Four Corners Canine, PPR-18-055

Please accept the following comments from El Paso County Public Health regarding the project referenced above:

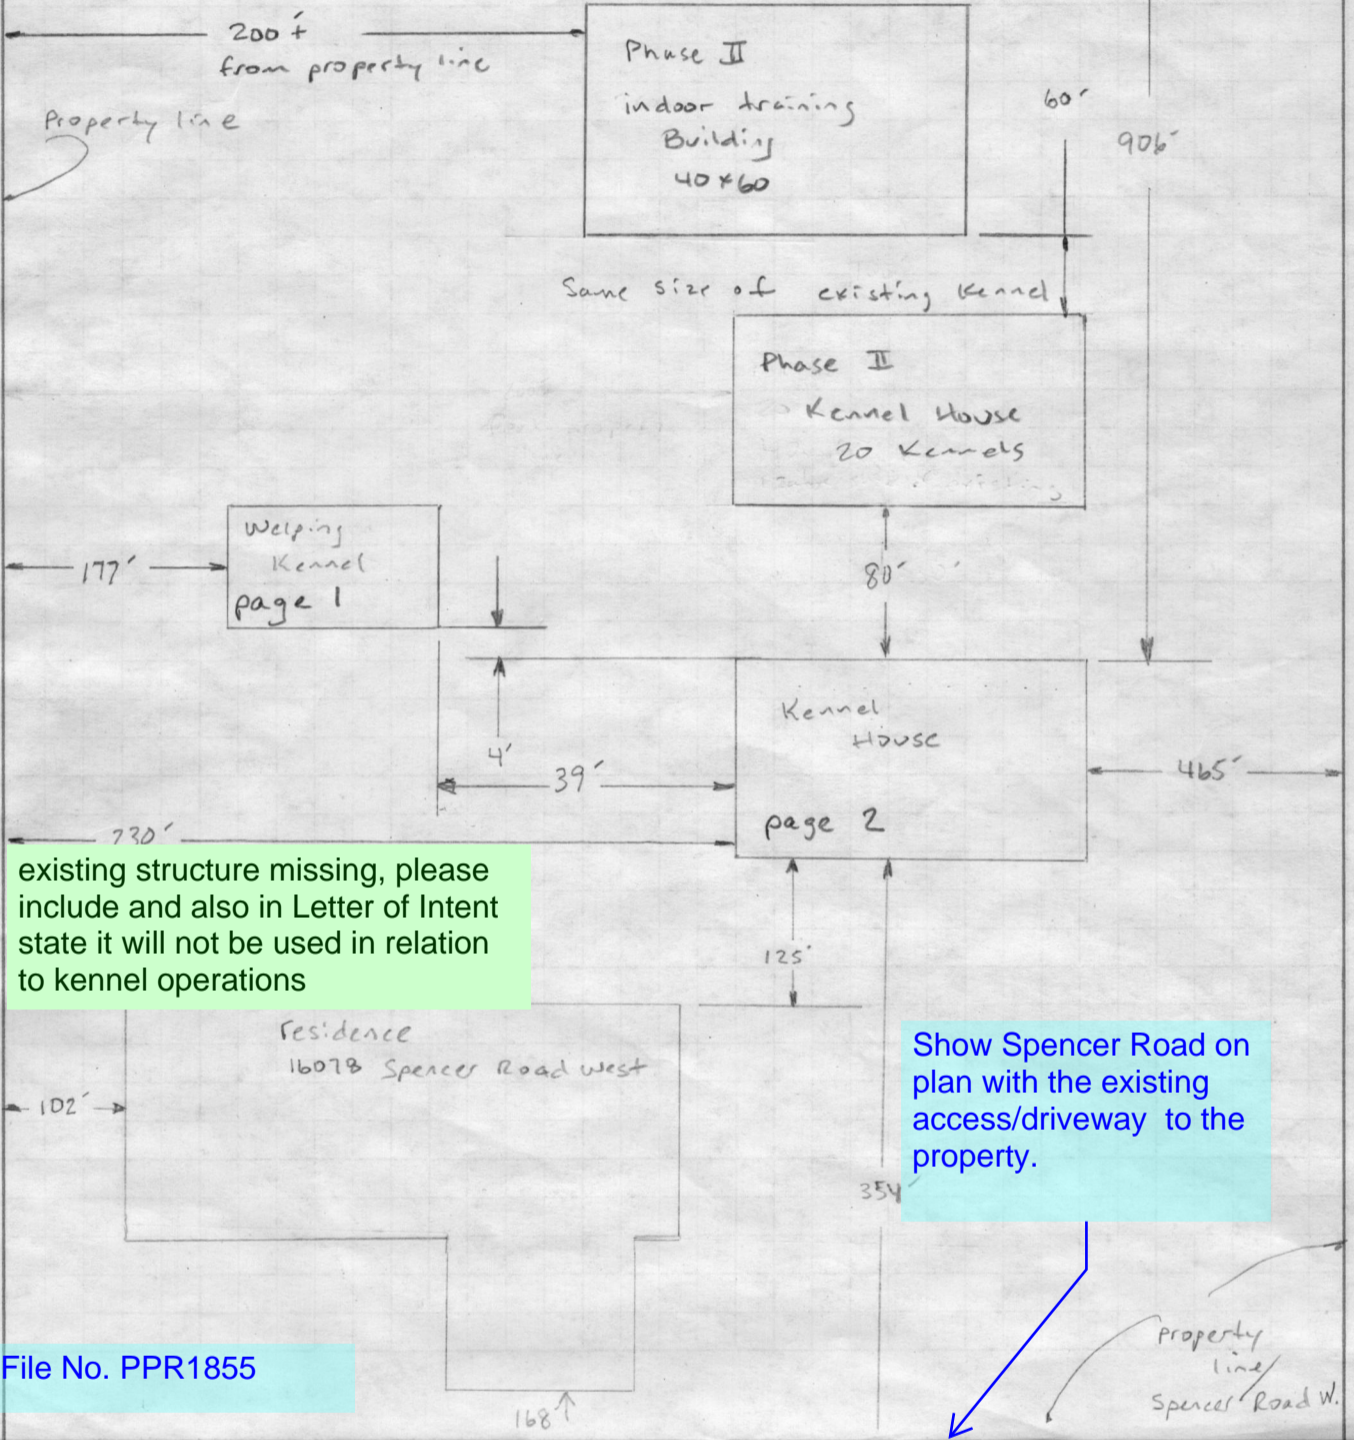
- **The Letter of Intent indicates an OWTS for the kennel is in the owners 5 to 7 year plan, and until then liquid waste will be mopped and solid waste will be disposed of as trash. The dirty mop water must be disposed of properly into a utility sink or toilet in the house connected to the existing OWTS, and not on the surface of the ground. Dog waste must be managed properly to help control nuisance odors, minimize flies and other insects. Solid waste should be bagged, tightly tied and placed in a covered waste container.**
